2765 Palladium Drive - Palladium Terrace (Phase 2)

Urban Design Brief

Site Plan Control Application

Pre-Consultation – Response to Urban Design comments (consolidated)

1 SITE PLAN
1: 400

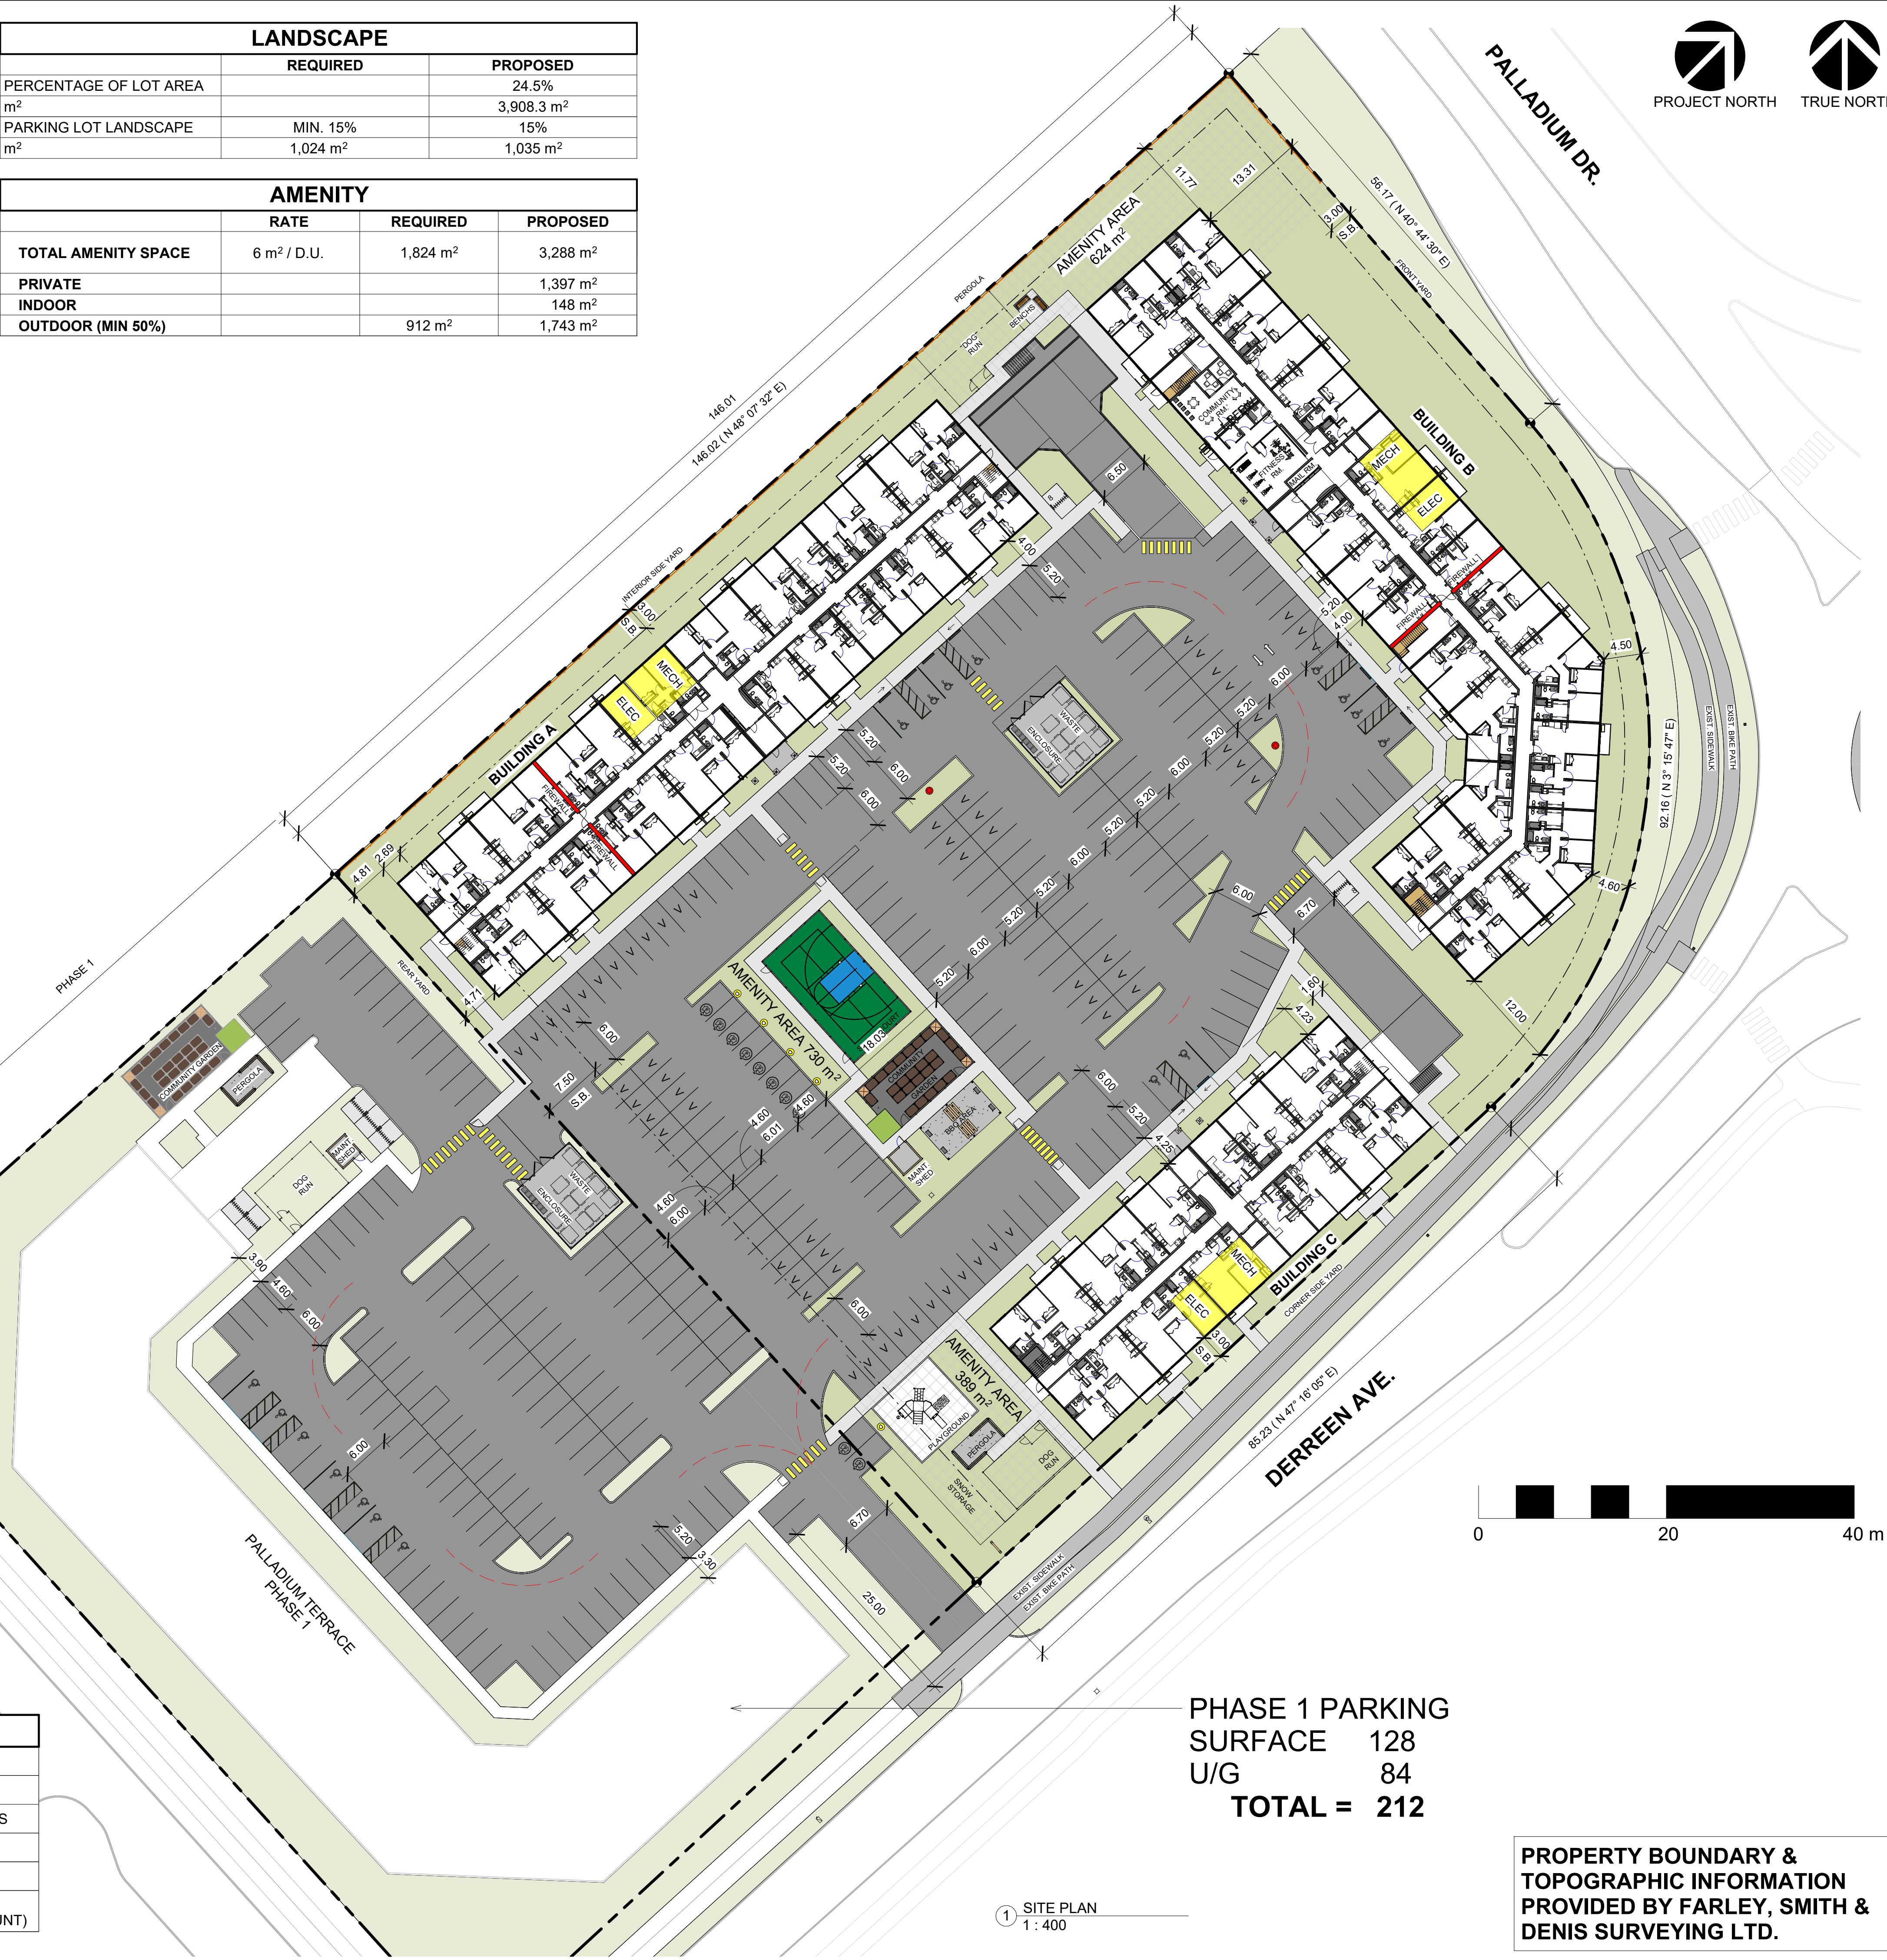
It appears that the lot lines have been incorrectly identified on the concept plan. For the purposes of applying zoning, please note that the lot lines are as follows: a) See zoning definitions for lot lines below. i. Front lot line – Palladium Drive ii. Corner lot line – Derreen Avenue	a) Noted. Site plan has been adjusted b) Noted. Zoning Summary chart has been updated. c) As the two lots will be considered one lot for zoning purposes, the rear yard setback should not apply as it is a shared lot line between Phase 1 and Phase 2.

iii. Side lot line - lot line abutting 2775 Palladium Drive iv. Rear lot line – lot line abutting 425 Culdaff Road b) Update the zoning summary chart to reflect the correct provided amounts per the appropriate lot line c) Ensure the required setbacks are provided. It appears Building A may not comply with the required 7.5m rear yard setback	
Site Access: a) Please remove the secondary access to the site/consolidate it with the access being proposed on phase 1 site. If the two sites are being coordinated and treated as one development, there is no need for two separate accesses along Derreen Avenue. b) Only other viable location for a secondary access into site may be on Culdaff maybe through phase 1 development due to traffic medians/proximity to the traffic circle. Applicant is encouraged to consider site access further before proceeding with the approval of phase 1 if a secondary access into the site is desired. c) Given the number of users of the proposed site access, consider removing/relocating parking spaces leading up to the driveway to reduce friction/queuing in this area.	a) Secondary access from Derreen Avenue has been removed. Access to the Phase 2 site will be through the Phase 1 site. b) No secondary access is being considered as it was confirmed that there are no issues with fire or emergency access with the single proposed access. c) Noted. Parking along the access has been mostly removed

Parking a) It is understood that the minor variance is being sought for resident parking on the site. b) Staff have concerns with the amount of surface parking being proposed on the site. Is there an opportunity to increase the size of the underground parking garage to accommodate more of the required spaces?	a) As Zoning By-law 2026-50 comes into force, a minor variance may not be required as the by-law does not prescribe minimum parking rates, rather provides maximum parking rates, which the proposal does not exceed. If this provision changes and a minor variance is required, it is understood that the variance must be approved by the Committee of Adjustment prior to SPC approval. b) Noted. At this time, expanded underground parking is not being considered.
Additional drawings and studies are required as shown on the SPIL. Please follow the terms of references (Planning application submission information and materials City of Ottawa) to prepare these drawings and studies. These include: a. Site Plan. b. Landscape Plan c. Building Elevations d. Conceptual Floorplans	Noted. Building elevations, floor plans, and landscape plans have been provided as part of the Site Plan Control Application.

Efforts should be made to consolidate the vehicular access proposed on Derreen Avenue with the Phase 1 development. September 2, 2025 Planning Comment: Please remove the secondary access to the site/consolidate it with the access being proposed on phase 1 site. If the two sites are being coordinated and treated as one development, there is no need for two separate accesses along Derreen Avenue.	Following confirmation that a single access to the two sites would not be an issue for fire and emergency access, the second access has been removed with the sole access route located on the Phase 1 side of the overall development.
There is an opportunity to enhance the amenity offerings by consolidating or sharing facilities between the Phase 1 and 2 developments.	As the two phases will operate as a unified development all amenities, indoor and outdoor, will be available for tenants of all buildings. Outdoor amenity areas have been spread throughout the site with pedestrian connections to all areas.

Like the Phase 1 development, staff are keen to see active entrances along public frontages with walkways and enhanced landscaping.	Similar to the Phase 1 plan, walkways have been provided from units along public frontages with city sidewalks present. Public frontages will include significant landscaping as per submitted landscape plans.
Efforts should be made to green the parking lot to reduce the urban heat island effect. Staff would be willing to support a further parking reduction for the inclusion of trees.	Noted. Efforts have been made to green the parking lot by providing shrubs and trees where possible, while providing adequate parking to meet our operational needs. The willingness to support a further reduction is noted.
Staff are looking to see pedestrian connections between the Phase 1 and 2 developments enhanced.	Sidewalk connections have been provided to connect the two phases. Additionally, pedestrian connections have been added to the central amenity area.
